Position Statement from National Highways at Deadline 7

Title:	National Highways Position Statement – Deadline 7
Reference:	TR050007
Applicant:	Tritax Symmetry
Proposal:	Application by Tritax Symmetry (Hinckley) Limited for an Order Granting Development Consent for the Hinckley National Rail Freight Interchange
Author:	National Highways (20040073)
Date:	27 February 2024

This submission forms National Highways’ Deadline 7 response which provides a position statement and comments on information received by Deadline 6 (27 February 2024).

Figure 2: Revised Furnessing Methodology

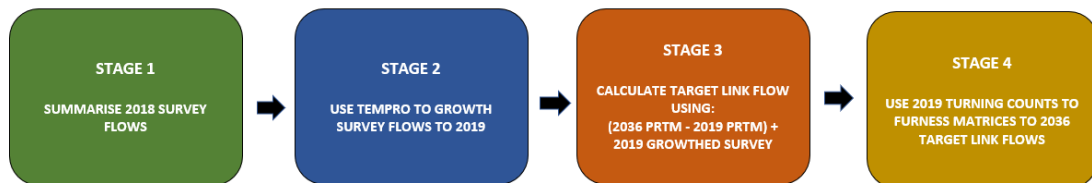
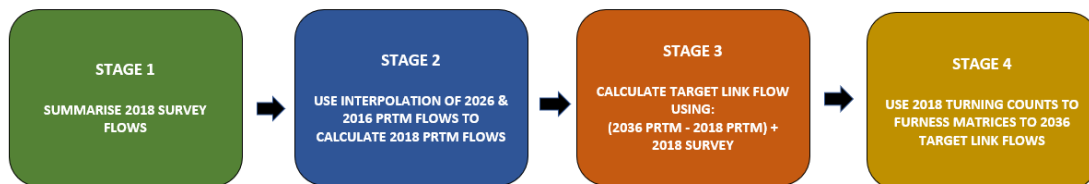
Our concern relates to the derivation of the matrix for the 2036 ‘With Development’ (WD), specifically that an incremental change is calculated between the ‘Without Development’ (WoD) 2036 Post-Furness matrix and the WD 2036 Post-Furness matrix. The furness process takes the link flows from the WoD and the WD future year assignments and then synthesises matrices to match the target link flows in each case. Therefore, the method is not directly calculating the positive and negative traffic impacts of the development proposals but is calculating the difference between two synthetic (Post-Furness) matrices. This method may distort the turning movement impacts of the development site as represented by the PRTM forecasting model. The result is that HGV turning movements between the A5(N) and the A4304(E) arm are likely to be underestimated. (It should be noted that this could potentially also result in an underestimation of traffic flows at the M1J20 further to the east of the Cross in Hand junction, where the assessment requirement is contested by the Applicant.)

We note that the impact of the Development (site + schemes) has been calculated by the Applicant from the PRTM forecast outputs as WD 2036 – WoD 2036. On several of the turn movements the impact of the Development has been to reduce the turn flows, i.e. negative traffic growth. For example, on the M69 mainline (between arms A and C) and between the Hinckley Rd E and W roads (between arms B and D).

The Applicant has then applied these development impacts (both positive and negative) to the 2023 Observed flows (i.e. “growth between PRTM 2019 and 2036 has been directly added onto the 2023 survey flows”). However, trips that the PRTM has removed from its 2036 WoD forecast year matrix for the 2036 with development (WD) case, cannot be subtracted from the 2023 Observed turn flows matrix if those trips were not observed to be using the roundabout in 2023. (i.e. trips that do not exist should not be subtracted).

An appropriately robust basis for assessment would be to use the 2023 Observed turn movements where the PRTM is forecasting negative growth from 2019 to 2036. Care also needs to be applied on those turn movements where the PRTM is forecasting negative growth as a result of the Development.
